Our Ref: P/10/20/PL

**Town & Country Planning Act 1990 (as amended)
Town and Country Planning (Development Management Procedure) (England) Order 2015
Application for Planning Permission**

Development Change of use of existing staff residential accommodation to be used as a separate unit of residential accommodation.

Location The Pagham Club 2 West Front Road Pagham

Existing Floor Plan

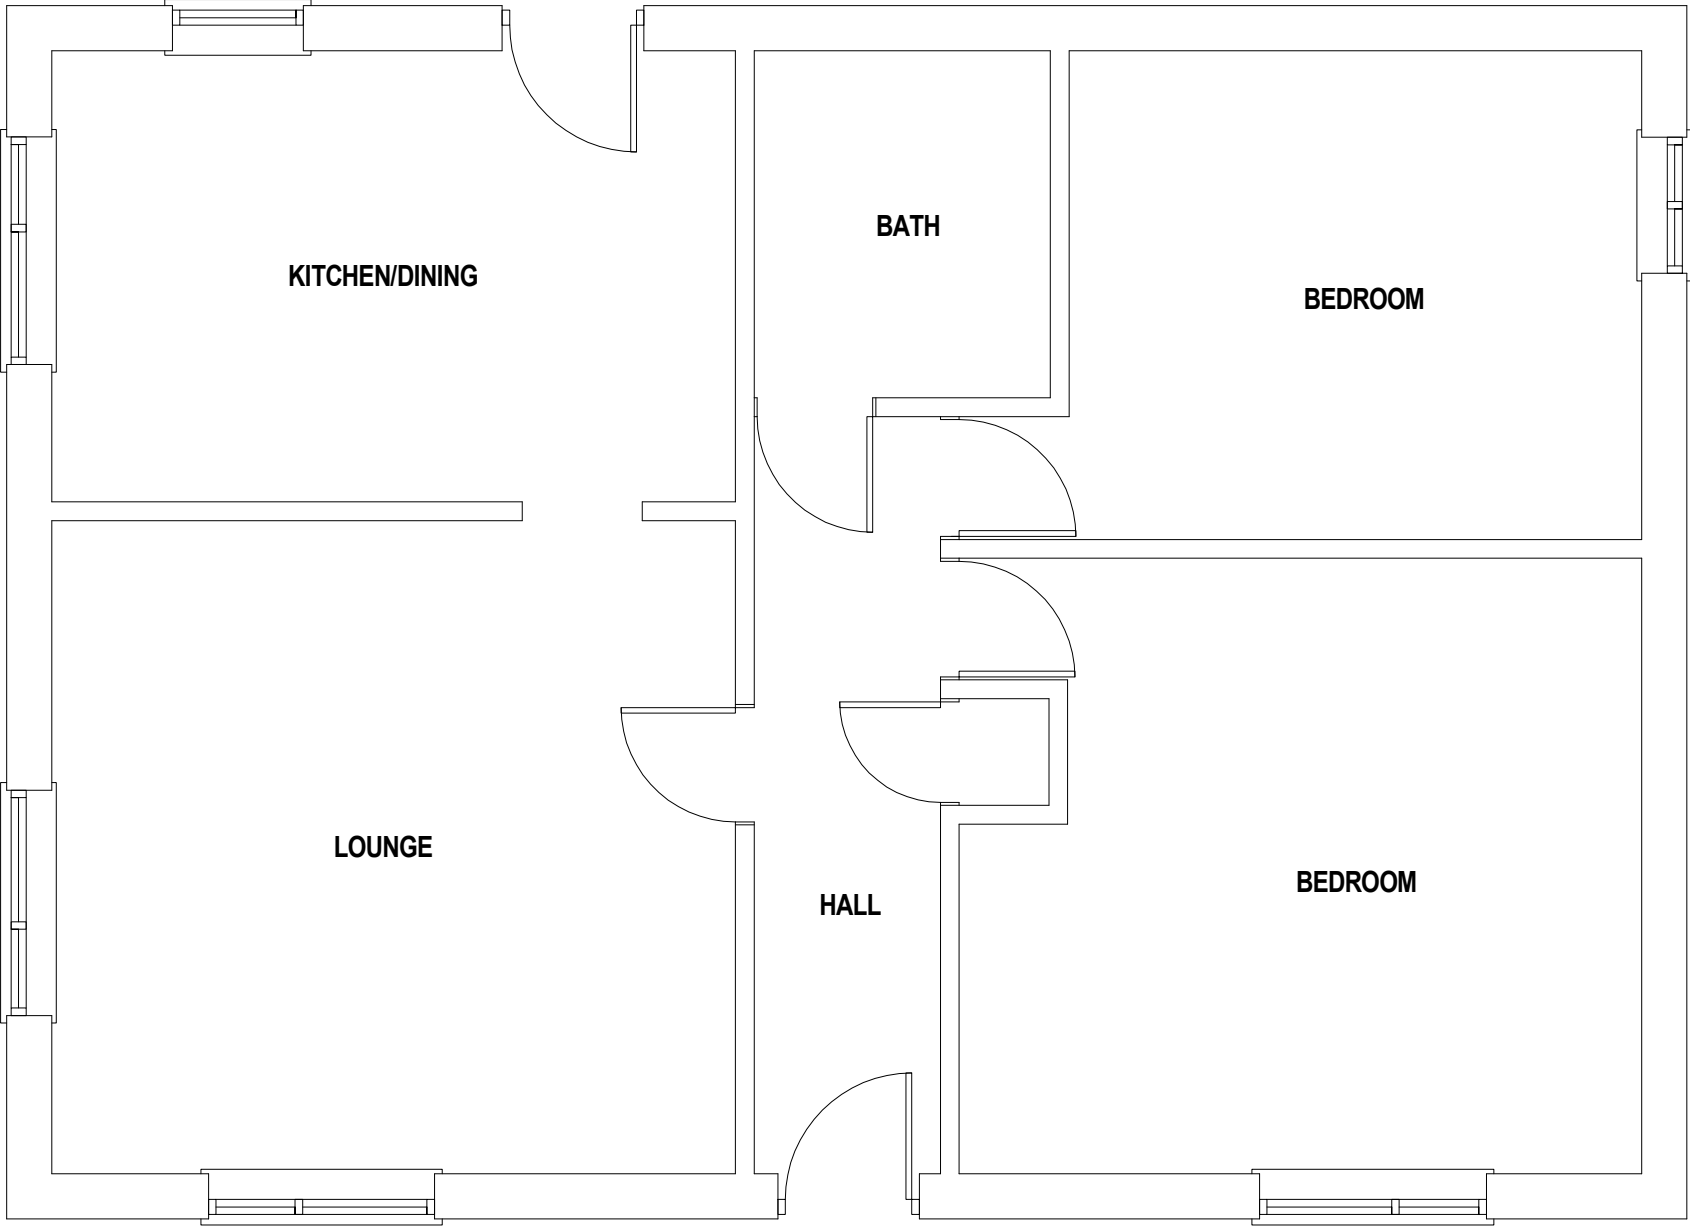
Floor Plans

Please submit 1 electronic or 3 paper copies of clearly labelled floor plans at a scale of 1:50 or 1:100. Further details can be found in the Validation Requirements List.

**Block Plan REV01**

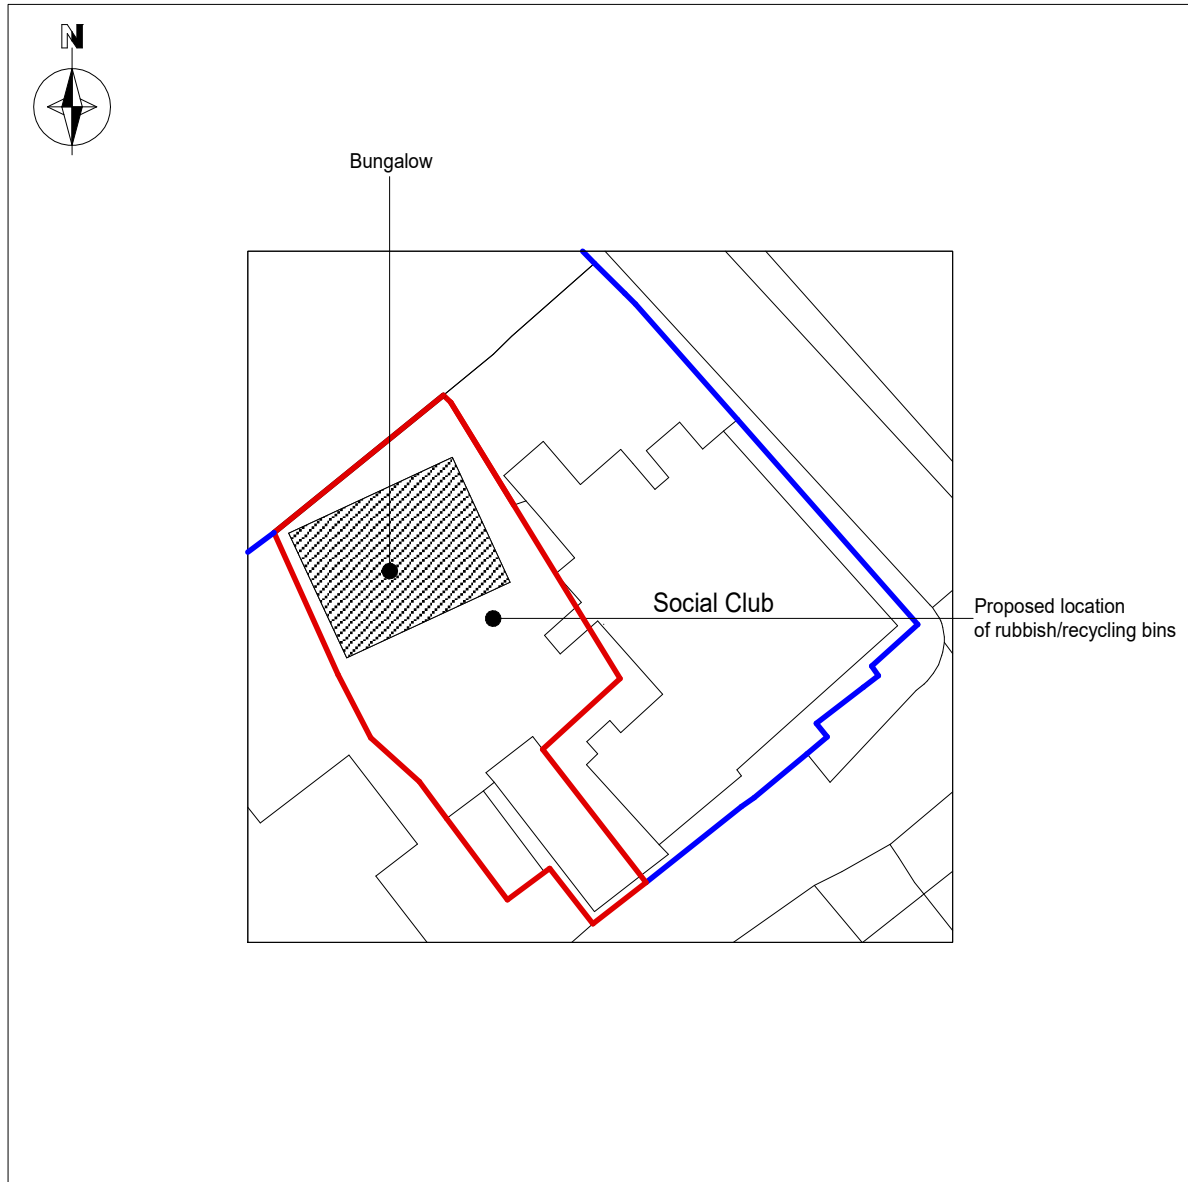
Block Plan Amend

Please show the position of the rubbish/recycling bins.
